WEST SUSSEX COUNTY COUNCIL CONSULTATION

TO:	Arun District Council FAO: David Spring
FROM:	WSCC - Highways Authority
DATE:	11 March 2020
LOCATION:	86 Annandale Avenue, Bognor Regis, PO21 2EX
SUBJECT:	BR/41/20/PL Change of use from C3 Dwellinghouses to a House in Multiple Occupation (Sui generis) including internal & minor external alterations.
DATE OF SITE VISIT:	n/a
RECOMMENDATION:	Advice
S106 CONTRIBUTION TOTAL:	n/a

PROPOSED GROUND FLOOR PLAN
1:50

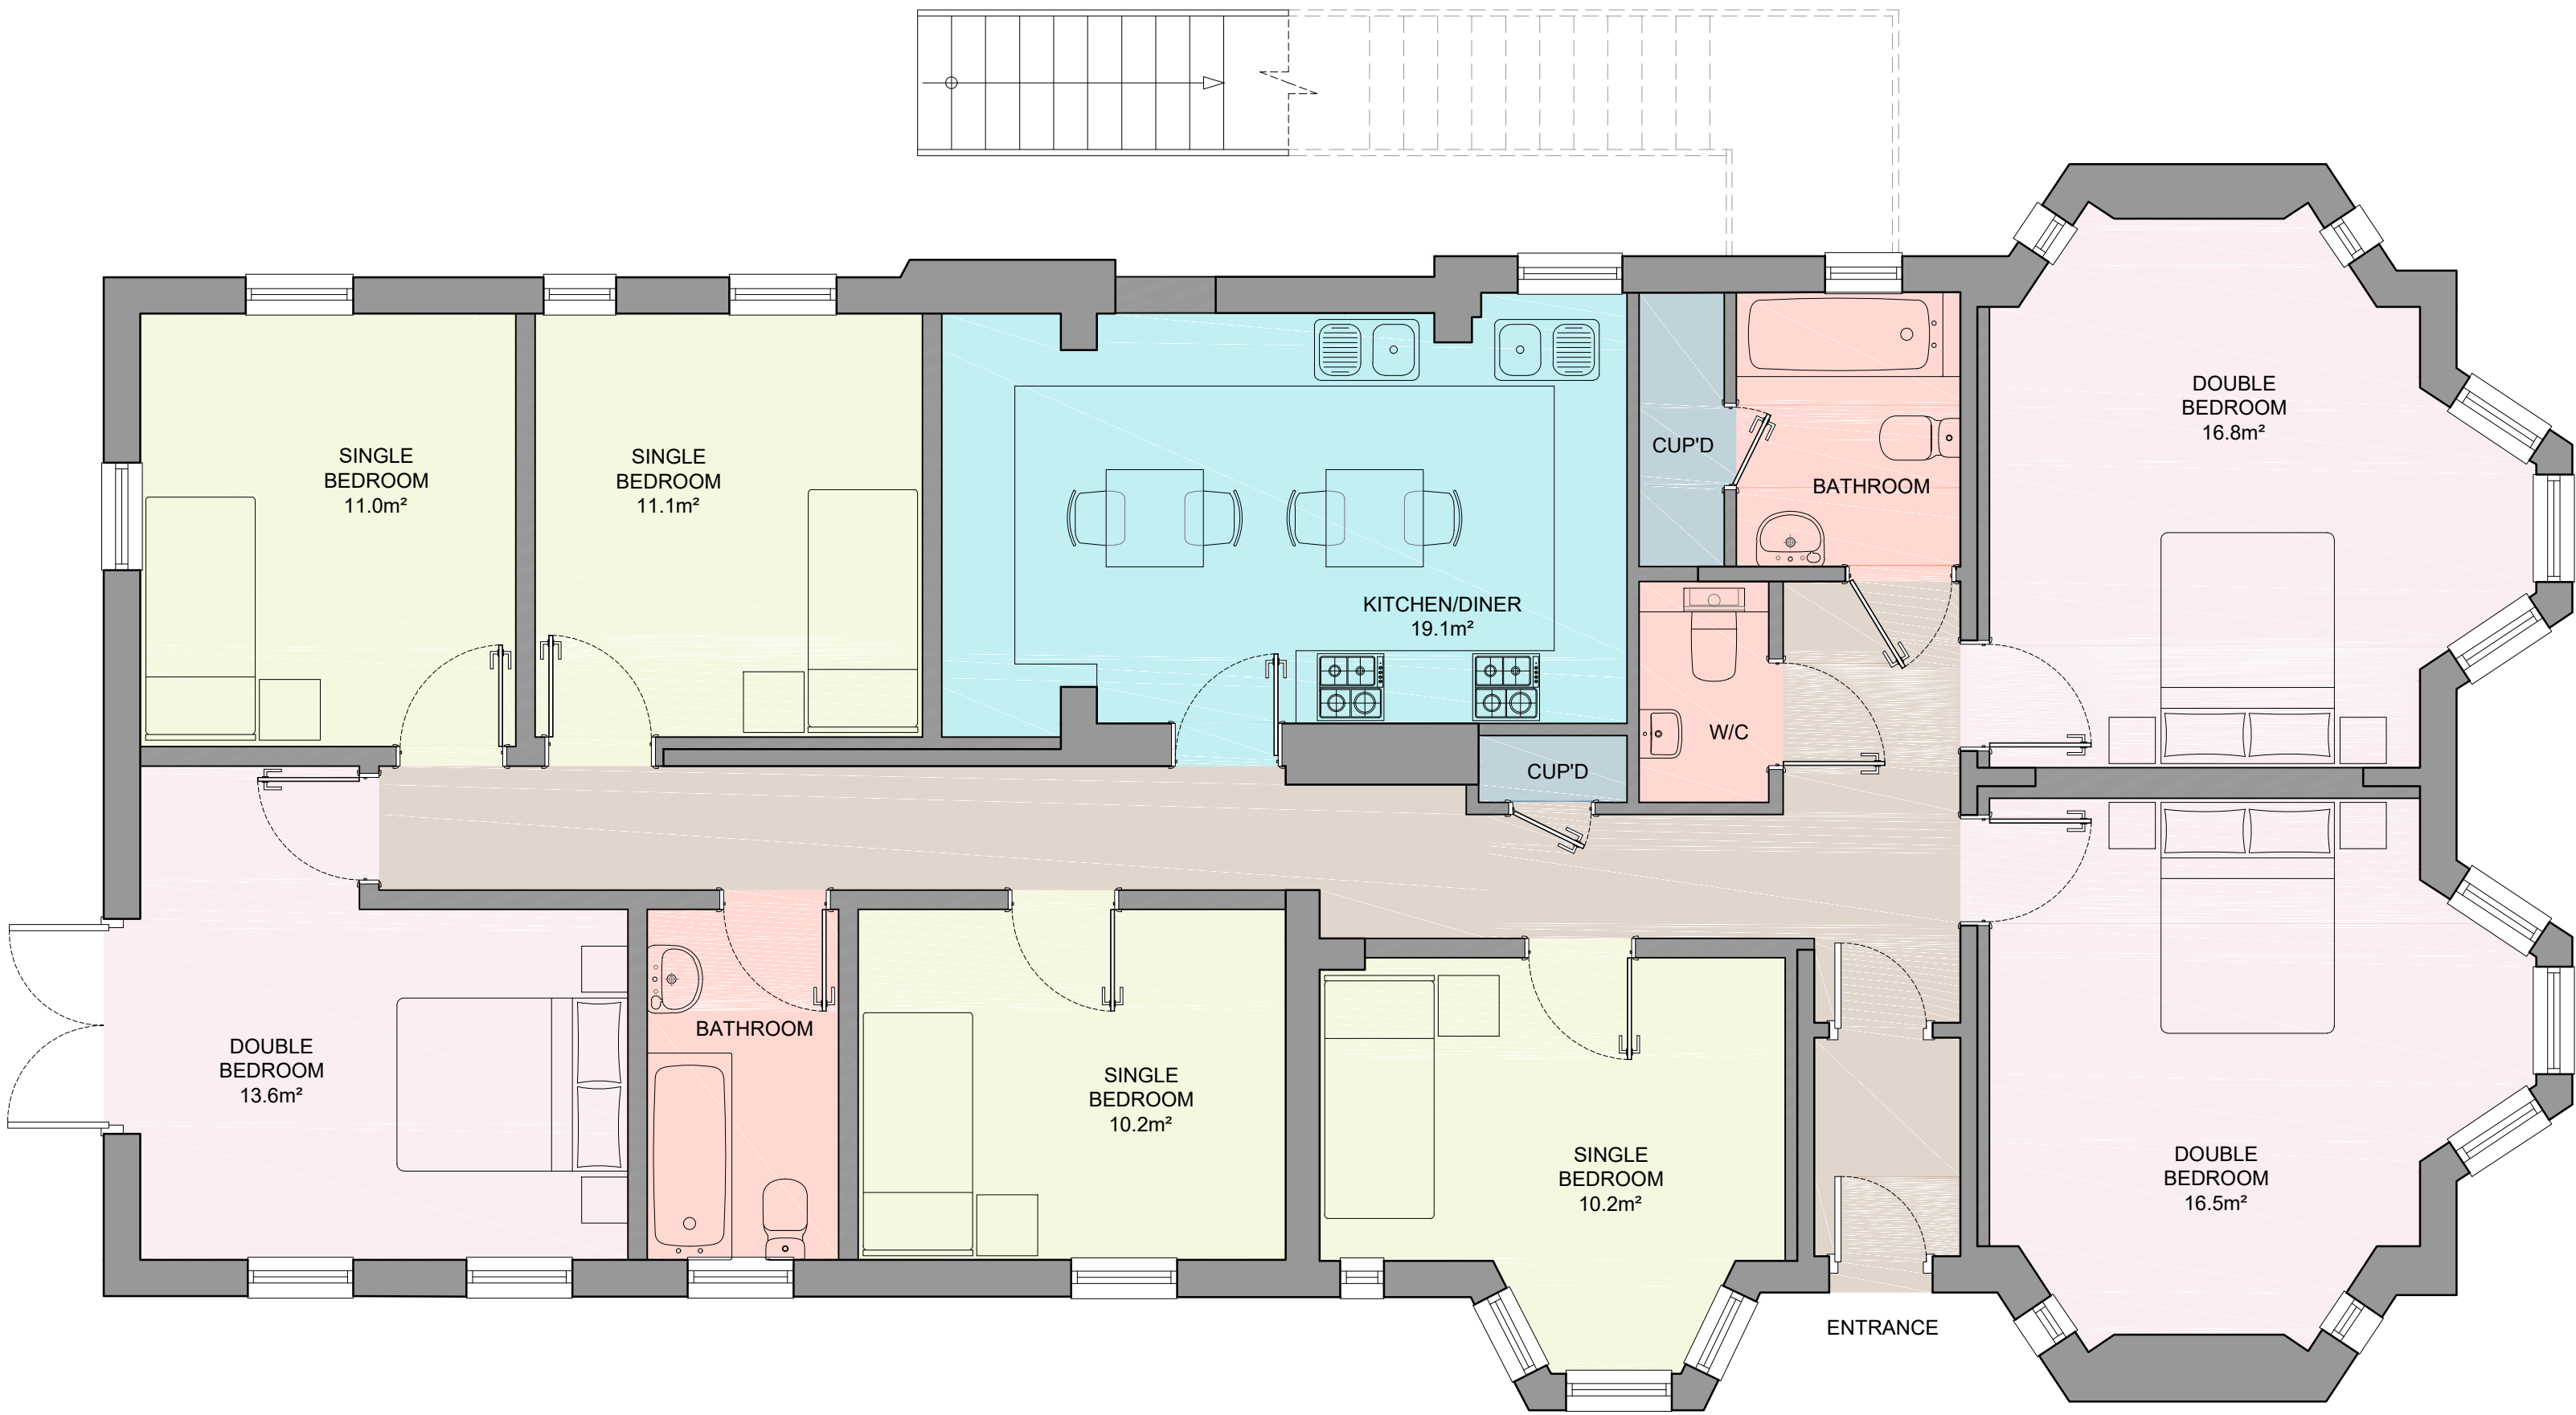
The Application Form does not include details of existing or proposed parking provision and the Design and Access Statement also makes no reference to on-site parking provision. However, local mapping does suggest that the site benefits from an existing vehicle crossover (VCO) which could provide parking for at least one vehicle. Clarification from the applicant as to whether this VCO will be retained and whether any parking would be possible on site would be beneficial.

The revised WSCC Car Parking Guidance does not set a standard for HMO use. Under the previous WSCC parking standards a demand of 0.5 spaces per bedroom would be anticipated. As such, a total of 6.5 car parking spaces may be provided for the proposal. Given the possibility that some rooms may be occupied by couples, it would not be unreasonable to expect a demand of 10 parking spaces. The existing C3 use of the site as 4 x 2-bedroom flats has the potential to generate a parking demand of 8 spaces which could potentially be required to be accommodated on-street if no off-street parking is currently possible. Whilst on-street car parking is limited in the immediate vicinity there are comprehensive parking restrictions prohibiting vehicles from parking in places that would be detrimental to highway safety. Given the additional demand for two parking spaces over the existing arrangement, we would not consider that highway safety would be detrimentally affected through the proposed nil car parking provision. The Planning Authority may wish to consider the potential impacts of this development on on-street car parking from an amenity point of view. This should be provided in accordance with WSCC standards.

applicant proposes to provide cycle storage on site which further reduces the reliance upon the private car, however details of this have not been provided and can be secured via condition.

If the LPA are minded to approve the application, a condition securing cycle storage would be advised.
